Consultation Response from KC, Conservation & Design**2023/92079 Rear of 23 to 43 Moor Lane, Gomersal, Cleckheaton, BD19 4LF****Outline application for erection of residential development of 10 dwellings, demolition of existing extension at 27 Moor Lane, widening of existing access and realignment of boundary walls.****Date Responded: 7.8.2023****Responding Officer: Sue Brooks****Responding Ref:**

Access Road Eastern Elevation (towards 25 Moor Lane) as proposed 1: 100

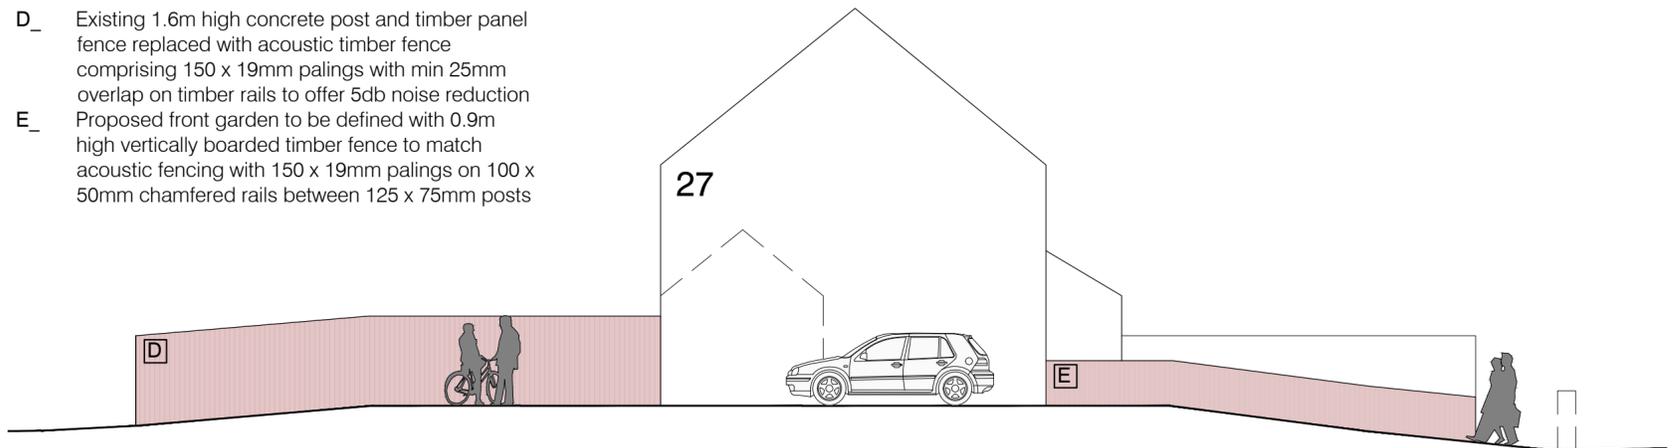
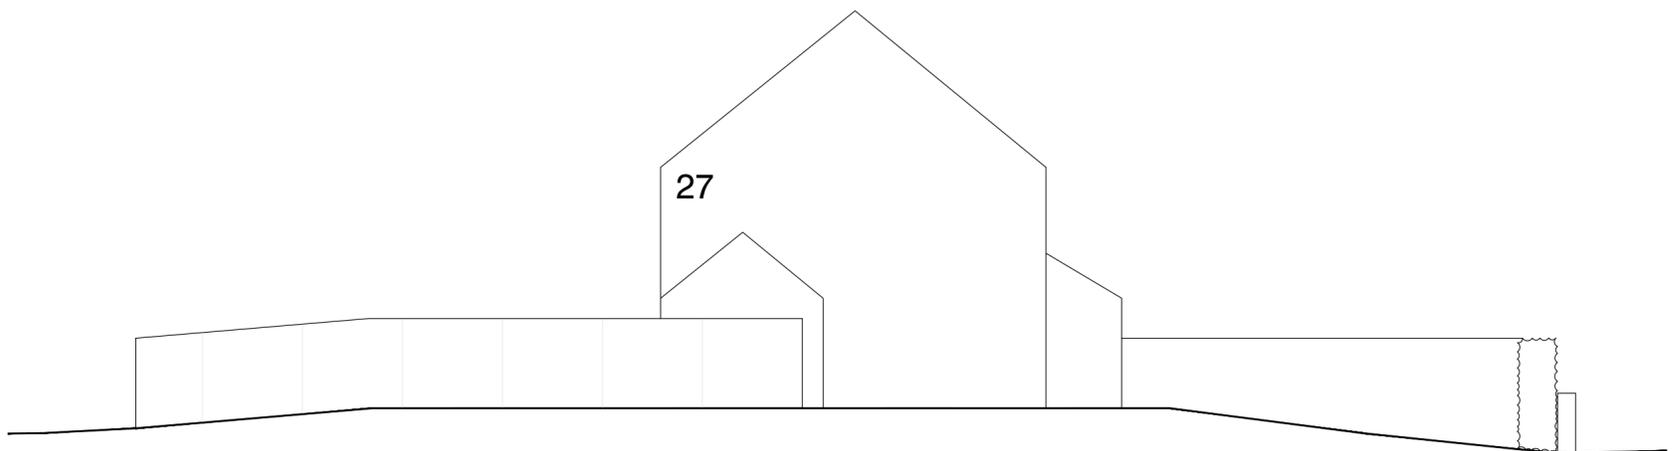
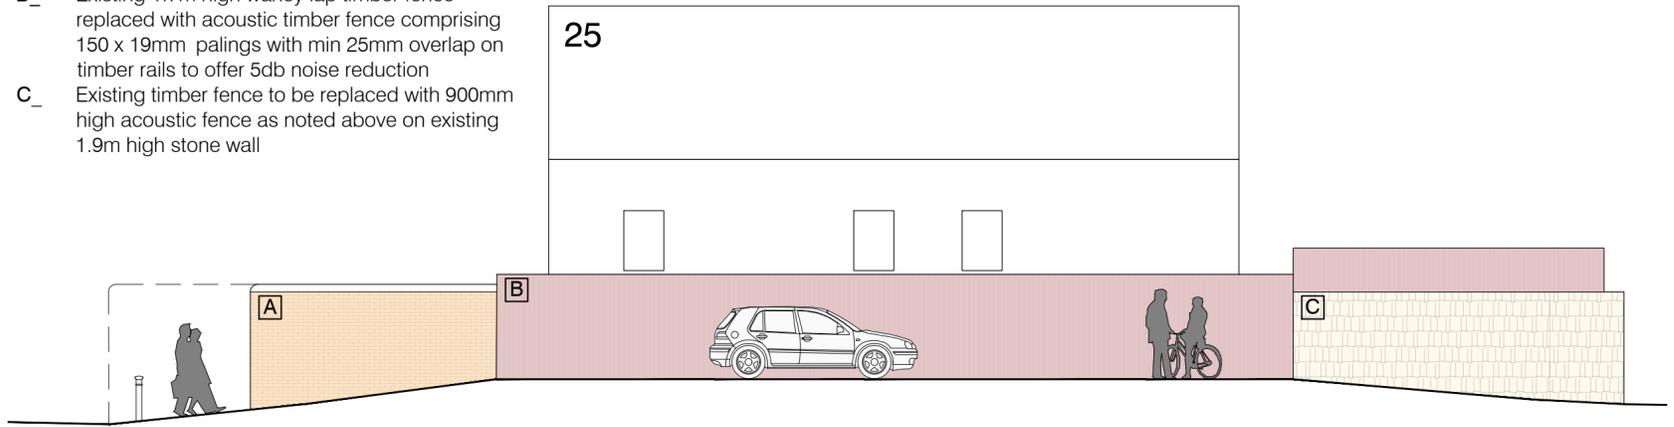
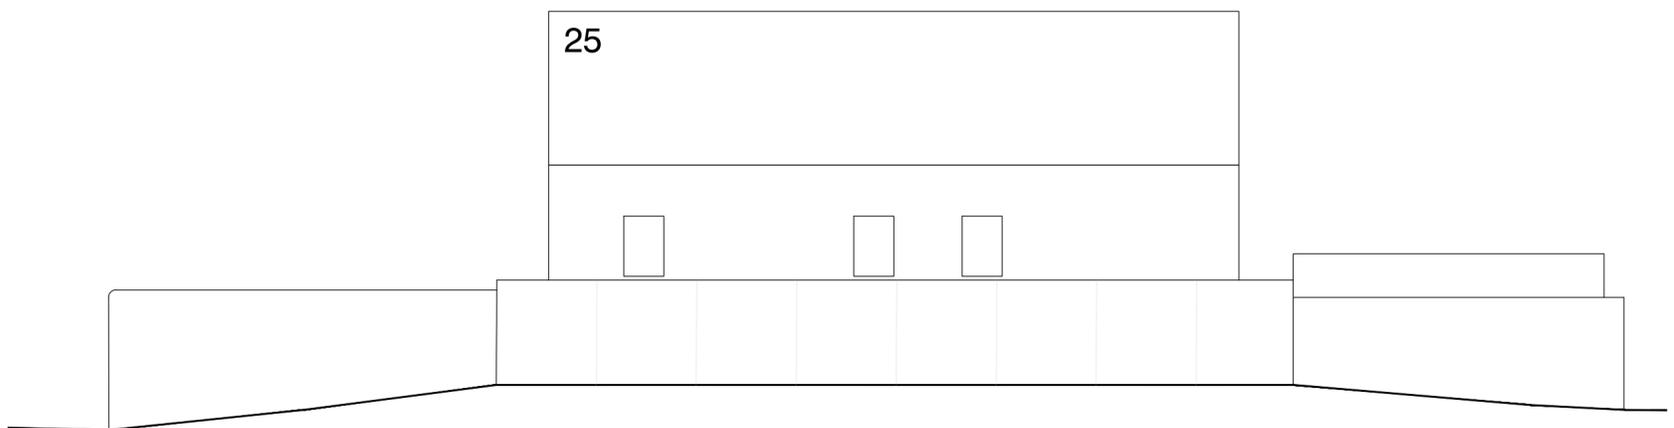
Where the front garden boundary wall of 25 Moor Lane is altered, we would recommend that the existing copings are reclaimed and re-bedded on the lowered wall. Instead of installing a modern fence on the front garden boundary of 27 Moor Lane, we would recommend that a natural stone wall with deep copings is built to reflect the local vernacular character of the traditional boundary features in this area.

We have concerns about the proposed installation of Manchester type bollards in this setting, as we feel that these are out of character in a street where the typical boundary feature is natural stone. We would welcome some reconsideration of this detail.
